RE: Exhibition of State Significant Development Application – Proposed Data Centre Development (SSD-68013714)

**PROPERTY: 43-61 Turner Road, Gregory Hills
Lots 14, 15, 16 and 17 in DP 28024**

Council staff have undertaken a review of the SSDA and supporting information and this letter provides feedback on the proposed development for your consideration.

Client	Scale 1 : 750	Sheet A1	Scale Bar
Project 43-61 Turner Road, Gregory Hills NSW 2557	Drawn By IL	Project Status SSDA	
	Checked By BY	Drawing Title SITE PLAN	
	Approved By AO	Job Number 240002	Drawing Number SSDA-A-054
			Issue K

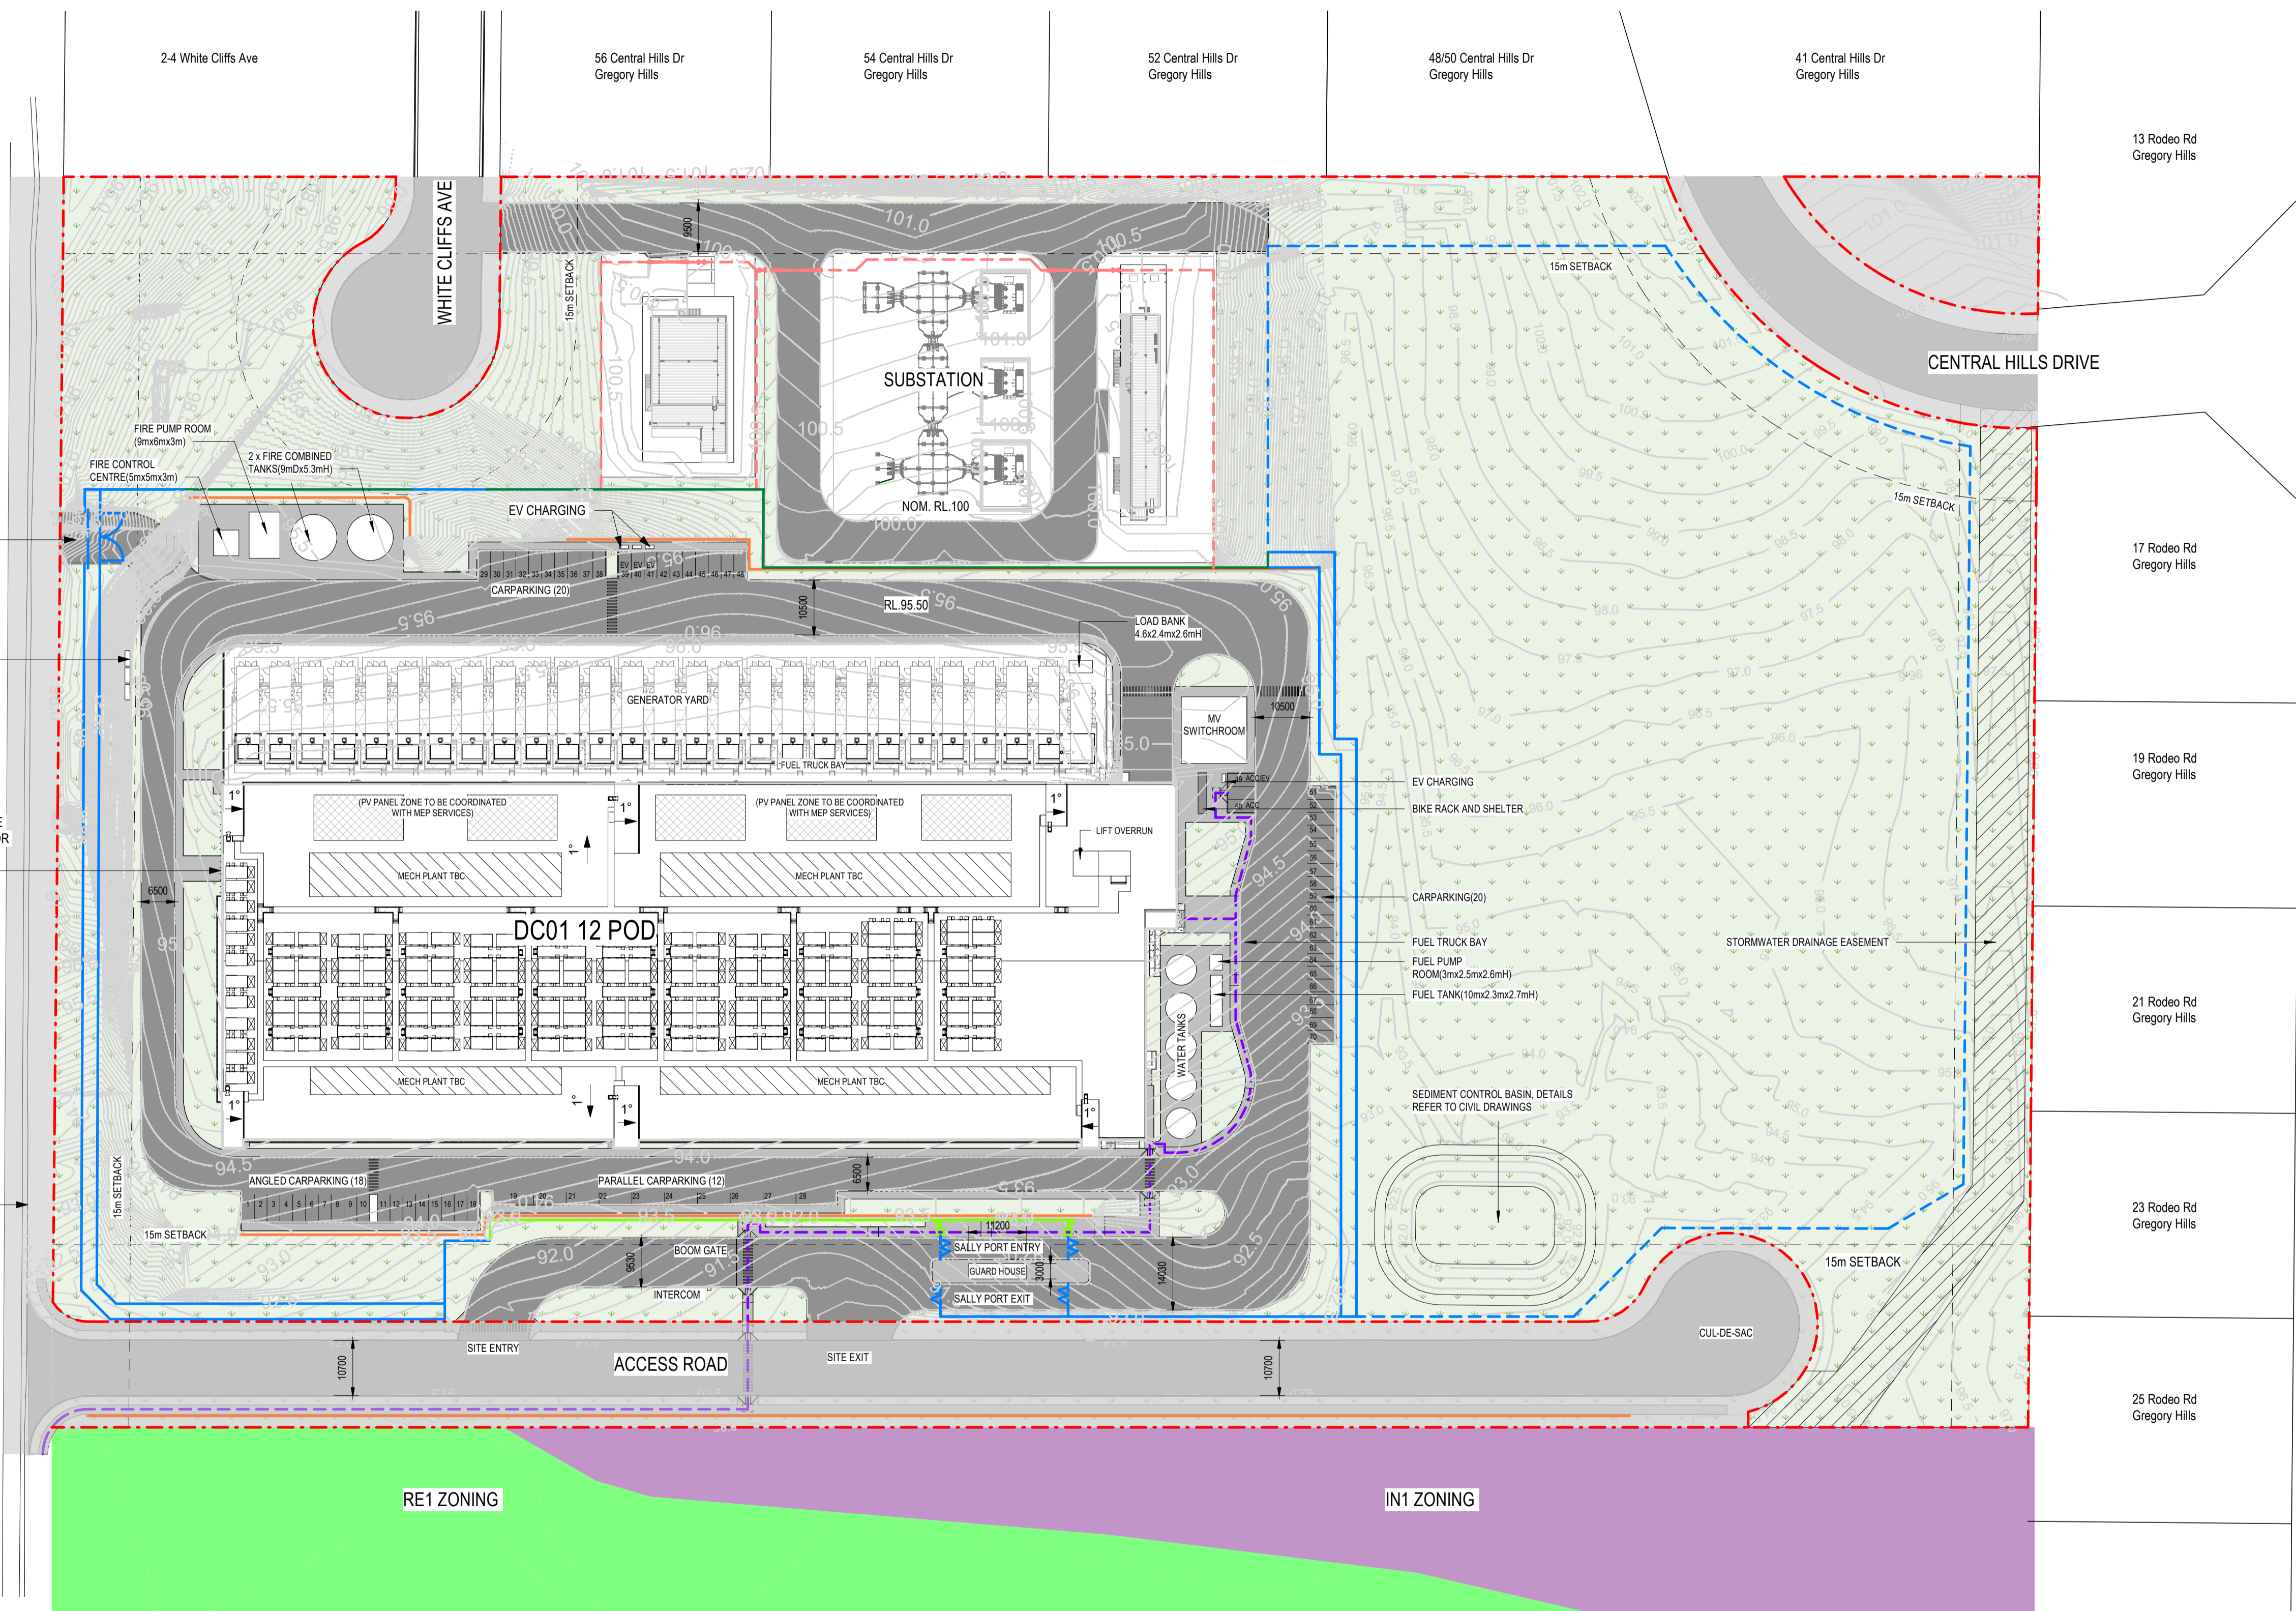
1. The traffic report identifies that 93 car parking spaces are required and 70 car parking spaces are provided. The proposal presents a shortfall of 23 car parking spaces and Council staff submit that the development should achieve full compliance with the minimum car parking rate.
2. A swept path assessment has only been provided from the Eastern Access Road (as proposed for heavy vehicles). A swept path assessment is required which details access from the cul-de-sac and western end of Turner Road.
3. A detailed parking plan is required to be prepared in accordance with the Australian Standards including car space and aisle width dimensions, accessible parking and swept path assessment.

1. The car park design is required to be amended in accordance with the requirements of Camden Council's Development Control Plan 2019, Section 2.18.3 – Car Parking Design Criteria. As the car park is highly visible from the public domain, Council recommends that the proposal must comply with the following requirements:

- a. Provide a 2.5m wide landscape bay between every 6-8 car parking spaces,
 - b. Provide a minimum 1m landscaping strip at the end of parking aisles, and

- c. Be landscaped generally in accordance with the Figure 2-12.
2. The proposed car park landscape species of Cupaniopsis Anacardioides should be substituted to a larger canopy tree species (10-20m) selected from Camden Council's tree species list. This would assist in providing further shade of hard surfaced areas, combat urban heat from extensive hard surface areas and soften the built form of the building by creating extra screening.

Drawing Title	ELEVATIONS - SHEET 1																																																						
Drawing Number	SSDA-A-150																																																						
Issue	F

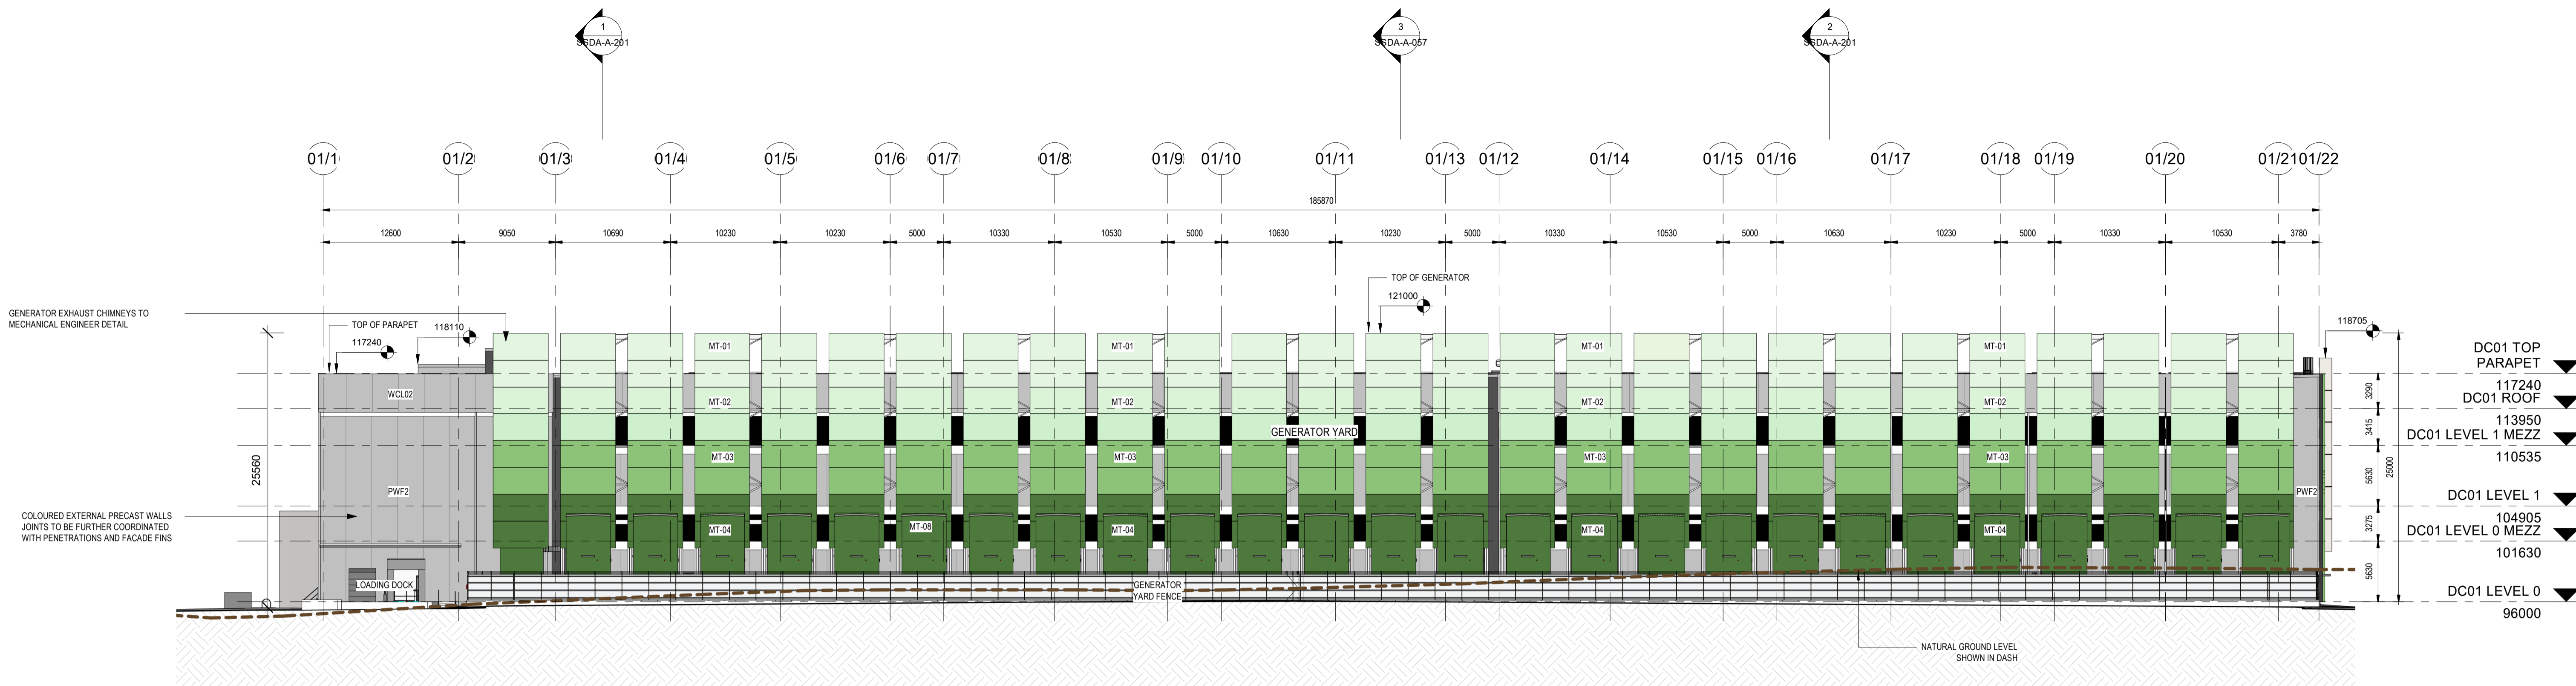
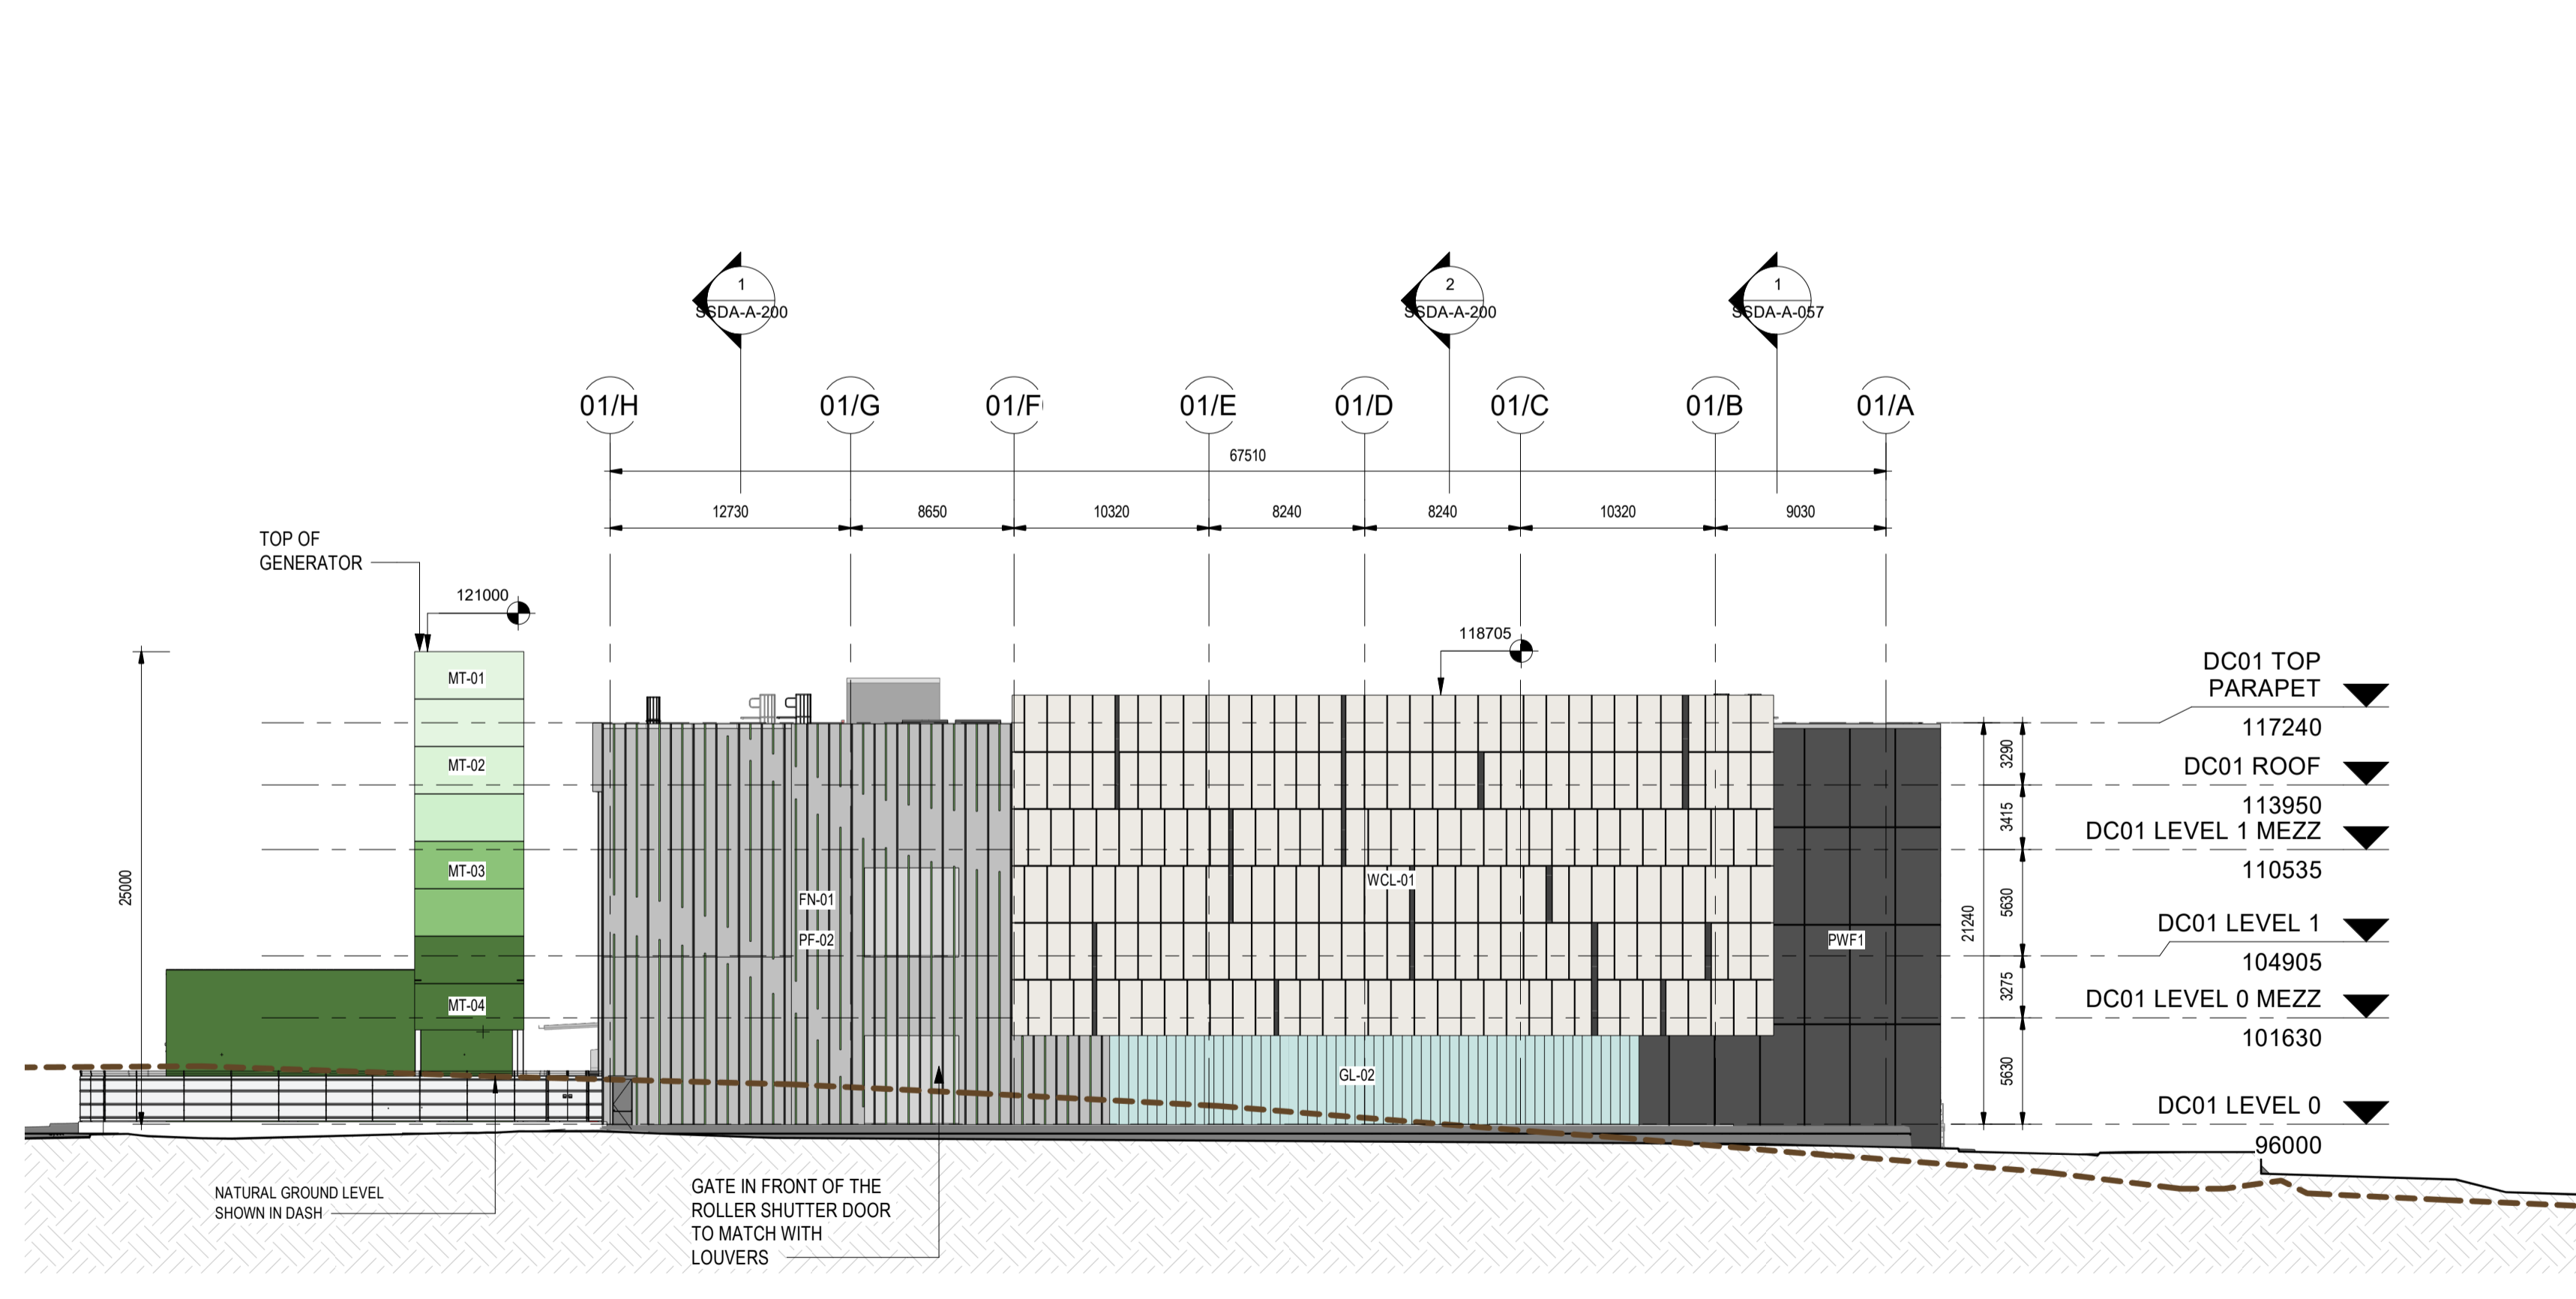
It is noted that the proposed development has a maximum building height of “*approximately 23m*” and thereby contravenes the maximum prescribed building height development standard of 15m. It is considered that the Clause 4.6 written request should accurately identify, and not approximate, the maximum height of the proposed development.
